Infill Site: Impact considerations not addressed - Objection.

This is a small site of special character and constraints and there are significant issues to be addressed, as part of consultation. I request the consultation period is extended to allow fuller assessment and that this application is determined at planning committee.

Drawing
**SECTION 38 ROAD
ADOPTION**

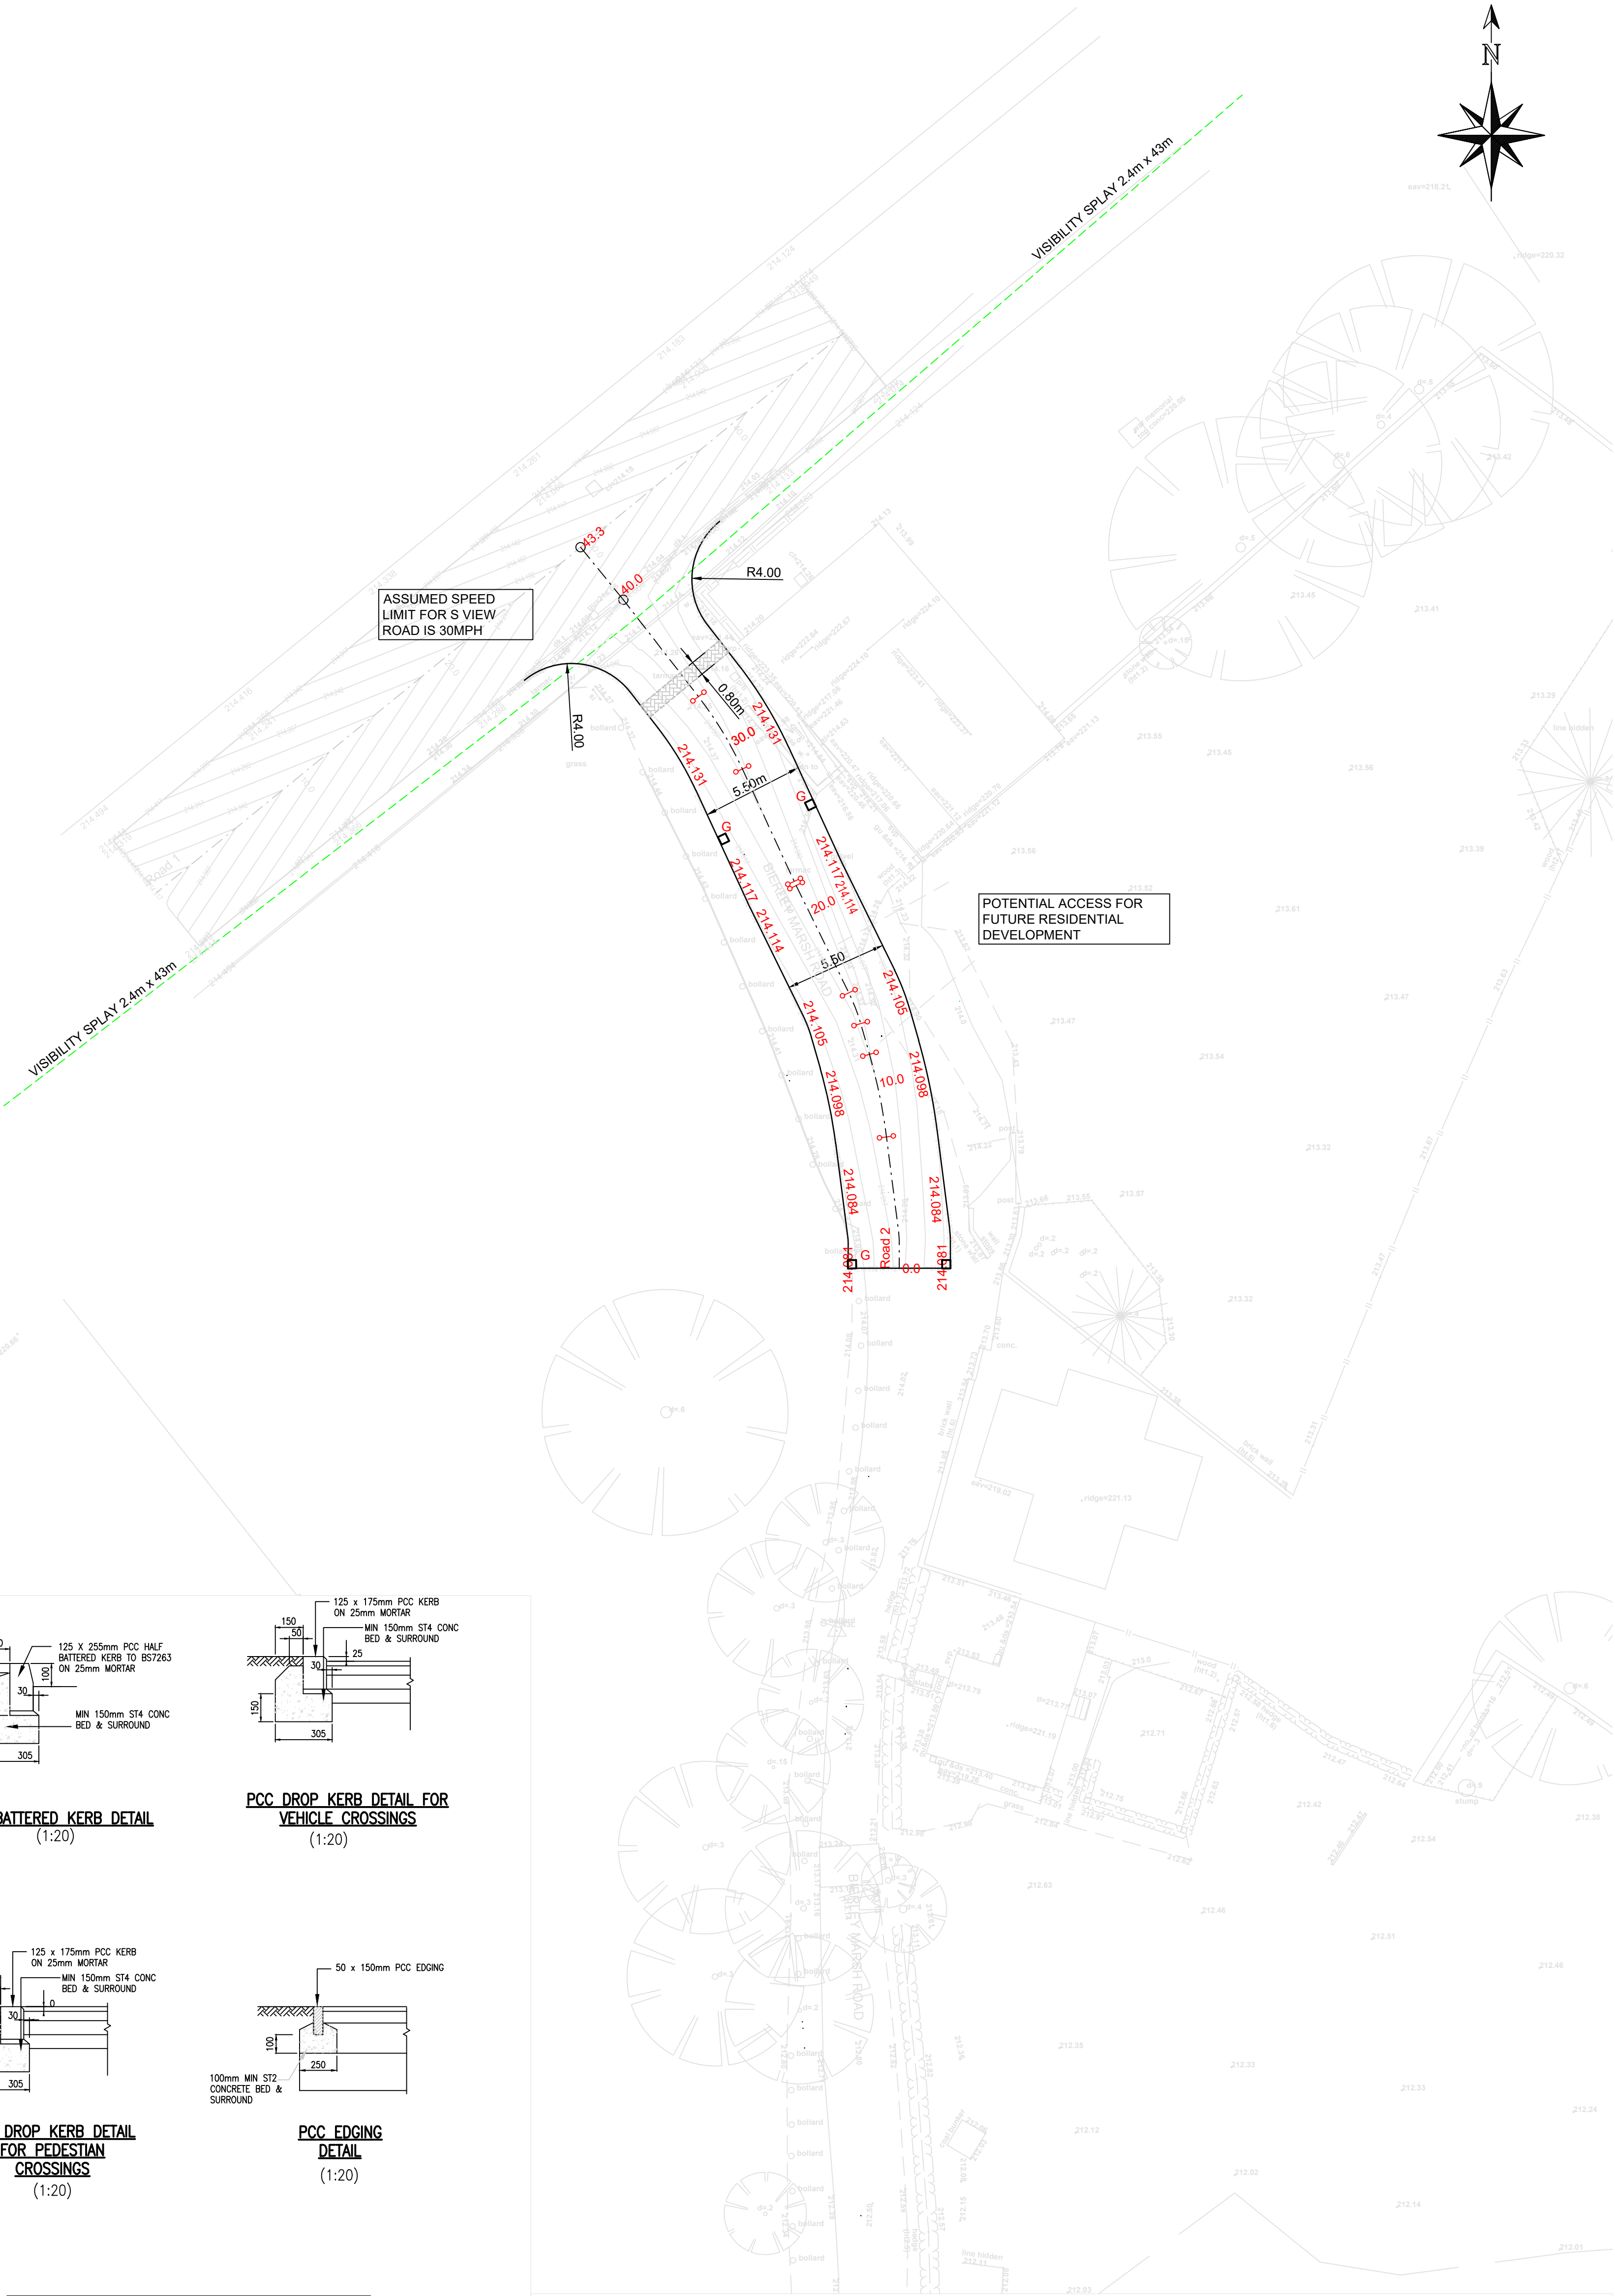
Highway Safety – the point of access/exit should have clear visibility, the visibility splays shown will be affected by accrued parking rights at Thornfield and parking (shown on the East Bierley Conservation Area Appraisal Plan (EBCAAP)) opposite St Luke's Hall.

- ref. at time of site visit, 4 cars were parked opposite St Lukes **"any design should provide for this existing parking**

Any proposal by the developer to only undertake road works to adoptable standards, i.e. not having road works adopted, should be dismissed. Pre-Planning comment as above states:

- road works to be **"offered for adoption"**.

Enough Space – the development should not be too dense. The layout gives the appearance of the properties being shoehorned into the site using an orientation for the terraces that is at an angle to Bierley Marsh. With an access drive, squeezing through narrow gap between terraces and Thornfield’s boundary retaining wall (which has an easement for maintenance-not shown), which seems unnecessary and unacceptable.

Access – development should consider and mitigate noise and disturbance from manoeuvring vehicles close to neighbours. The developer has made no efforts to mitigate these impacts, the majority of vehicle movements appear to be adjacent or close to the southern boundary retaining wall with Thornfield and close to habitable rooms.
